DRAWING NUMBER	DRAWING REVISION	REFERENCE NUMBER	S75W ALTERATIONS	COMMENTS
01 Location / Site Plan	D	-	No Change	
02 Site / Ground Floor Plan	D	1.	Ground floor planning altered	Please see comments below to Drawing Number 04 Ground Floor.
03 Basement	D	2. 3.	Disabled car space moved closer to lift Plant rooms included and coordinated	Compliance with AS2890.
04 Ground Floor Plan	D	4. 5. 6. 7.	Reduced car parking from 4 to 3 at rear of building Substation relocated Reception area modified Inclusion of common laundry	Ramp size increased - compliance To suit Energy Australia
05 / 06 / 07 / 08 / 09 / 10 / 11 Typical Floor Plans	D	8. 9. 10. 11.	General internal planning changes Windows introduced to Southern facade Extend of Glazing reduced to West facade – Windows to ensuites deleted Balconies introduced, louvers deleted, DGU introduced for increased ESD <u>No change to apartment types (mix), number of rooms or floor size.</u>	E.g. bathroom layout, linen rooms etc. The additional windows allow for cross ventilation of these apartments and an increased amount of natural light to improve the amenity. In combination with the introduction of DGU (double glazed units) throughout the project t

Roof Plan
1 : 100

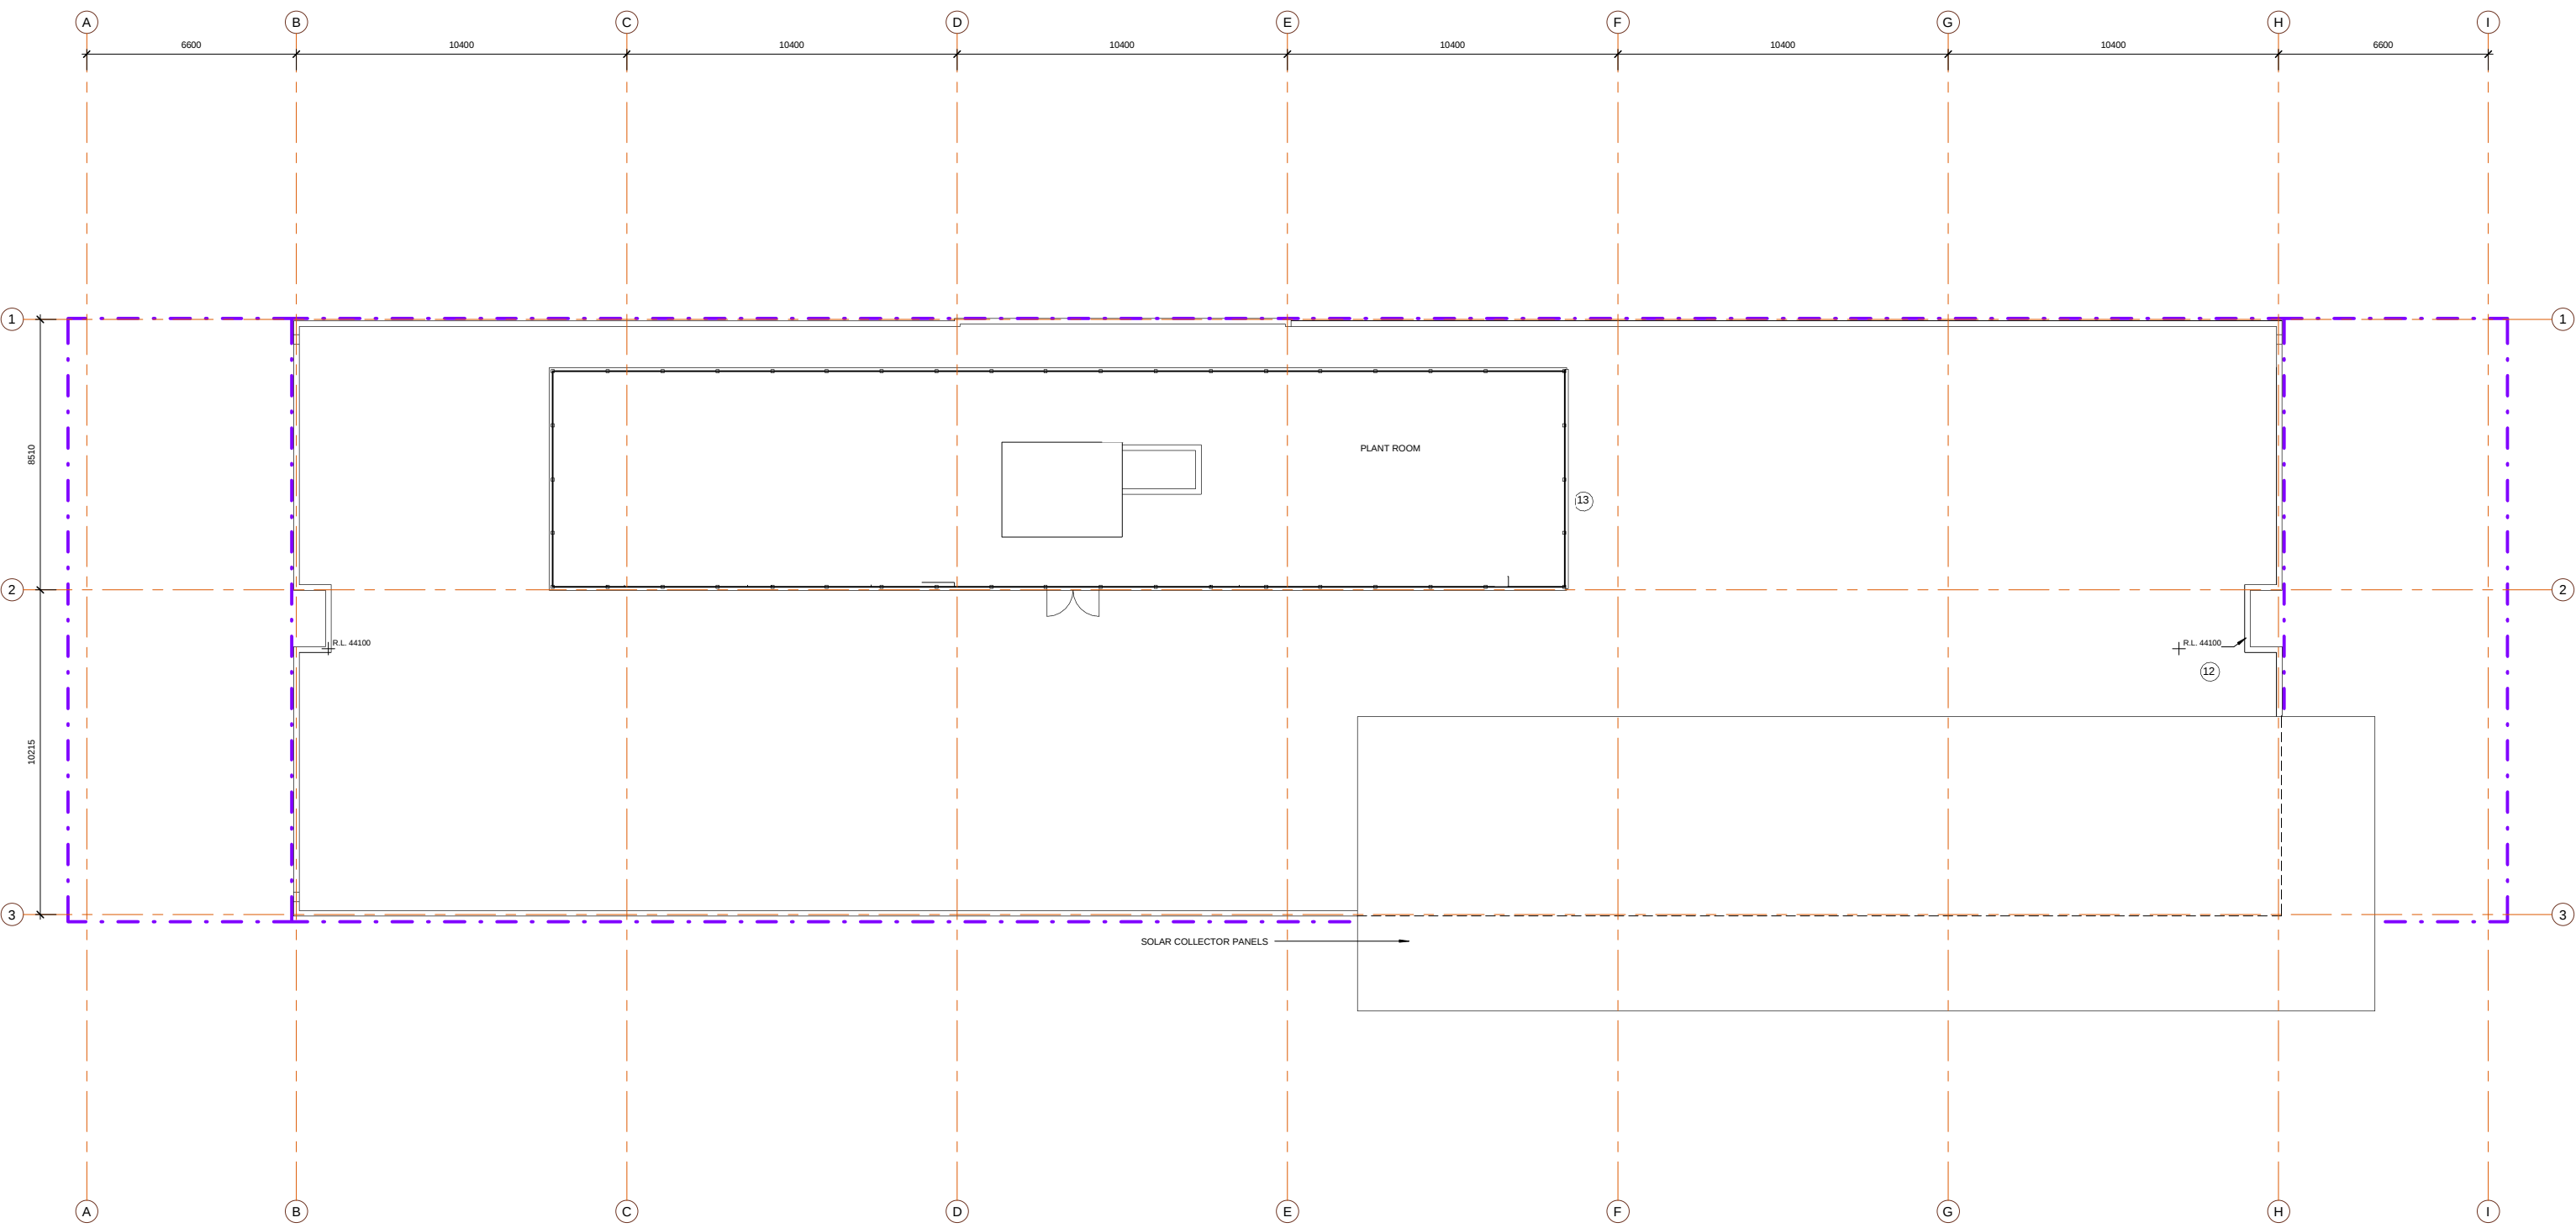
12 Roof Plan	D	12. 13.	Parapet RL Increased Plant room moved towards the South	There has been no increase in overall height. The previously approved height at RL 46.100 (top of plant room) has been maintained. The lower parapet has been raised by 980mm during the design development phase to facilitate structural requirements, roof drainage, insulation and services accommodation.
13 West Elevation	D	10. 11. 13. 4. 12. 14.	Levels 1-7 & Roof: Extend of glazing reduced to West facade – Windows to ensuites deleted Balconies introduced, louvers deleted, DGU introduced for increased ESD Plant room moved towards the South Ground Floor: Reduced car parking from 4 to 3 Parapet RL Increased Roof RL raised to accommodate insulation and services	Please refer to comments above. To facilitate structural requirements, roof drainage, insulation and services accommodation

16 External Perspective (East)		-	No Change	
17 External Perspective (West)		13.	Plant room moved towards the South	This change has been done to reduce transfer of services across the roof and material to a minimum.

Project
QUEST - SYDNEY OLYMPIC PARK
EDWIN FLACK AVENUE, HOMEBUSH BAY, NSW 2127
Drawing Title
West Elevation

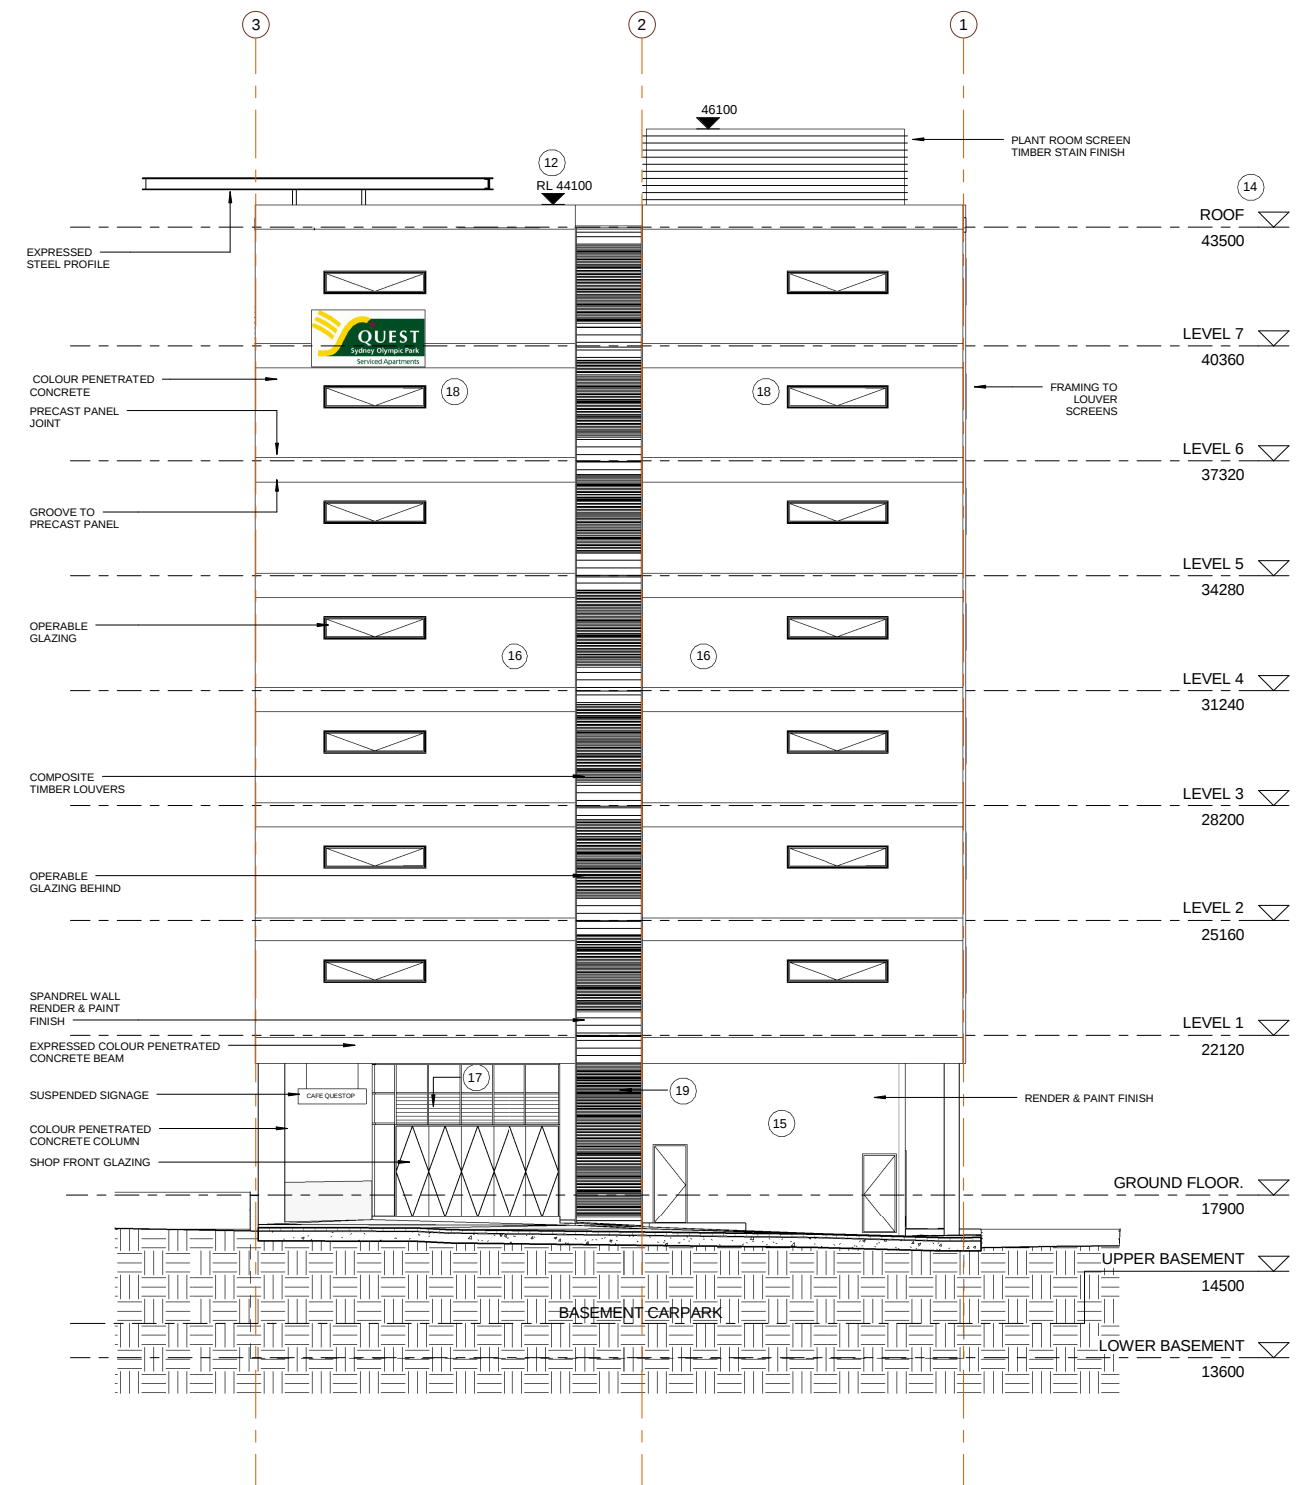
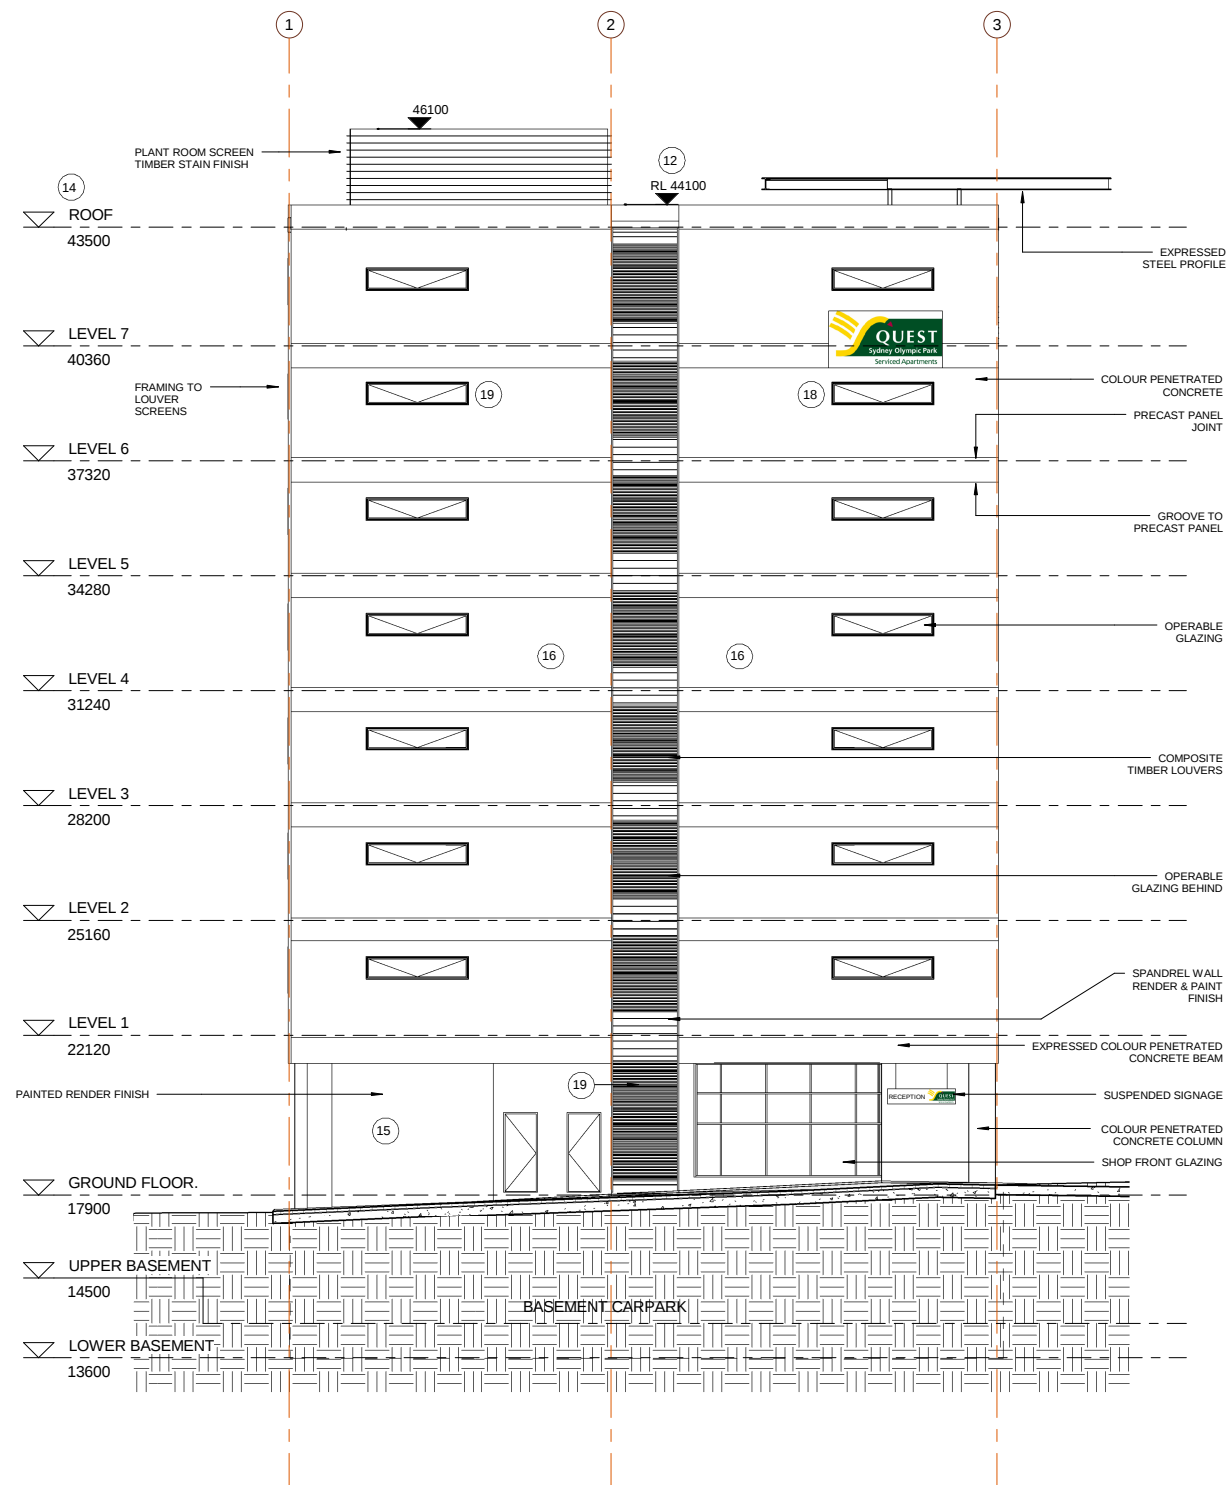
DRAWING NUMBER	DRAWING REVISION	REFERENCE NUMBER	S75W ALTERATIONS	COMMENTS
continued		15.	Composite timber cladding changed to render & paint	The material change on ground floor is limited to the back of the building. The major pedestrian pathways at ground level are on the opposite side of the building along Edwin Flack Avenue where no substitution of materials has been made. Therefore the extent of material substitution on ground level is regarded as acceptable and suitable for the intended use of the rear lane (i.e. deliveries, service vehicles etc.).

16.	Concrete finish changed from honed to colour penetrated concrete	Honed finish cannot be applied to all surfaces of the precast elements. Therefore a high quality look alike substitute has been selected that allows a uniform look even to critical areas such as balcony hobs, returns and grooves.
14 East Elevation	D	12. 13. 14. 16. 17.	Parapet RL Increased Plant room moved towards the South Roof RL raised to accommodate insulation and services Concrete finish changed from honed to colour penetrated concrete Operable louvers introduced to shop front facade	Please refer to comments above. This has been a design development change to facilitate natural ventilation on the ground floor and further reduce energy demand of the building to achieve the equivalent 4 star Green Star rating.
15 North / South Elevation	C	12. 14. 15. 16. 17. 18. 9. 19.	Parapet RL Increased Roof RL raised to accommodate insulation and services Composite timber cladding changed to render & paint (Ground Floor) Concrete finish changed from honed to colour penetrated concrete Operable louvers introduced to shop front facade Window length reduced and amended to operable windows Windows introduced to Southern facade Fixed composite timber louvers within recess extended to ground floor	Please refer to comments above. Longer windows would have run through wardrobes and past walls. Therefore large parts of them would require to be blanked off. This is not regarded as an improvement to the design and therefore the length has been reduced. To improve the extent of high quality finishes and quality of design.
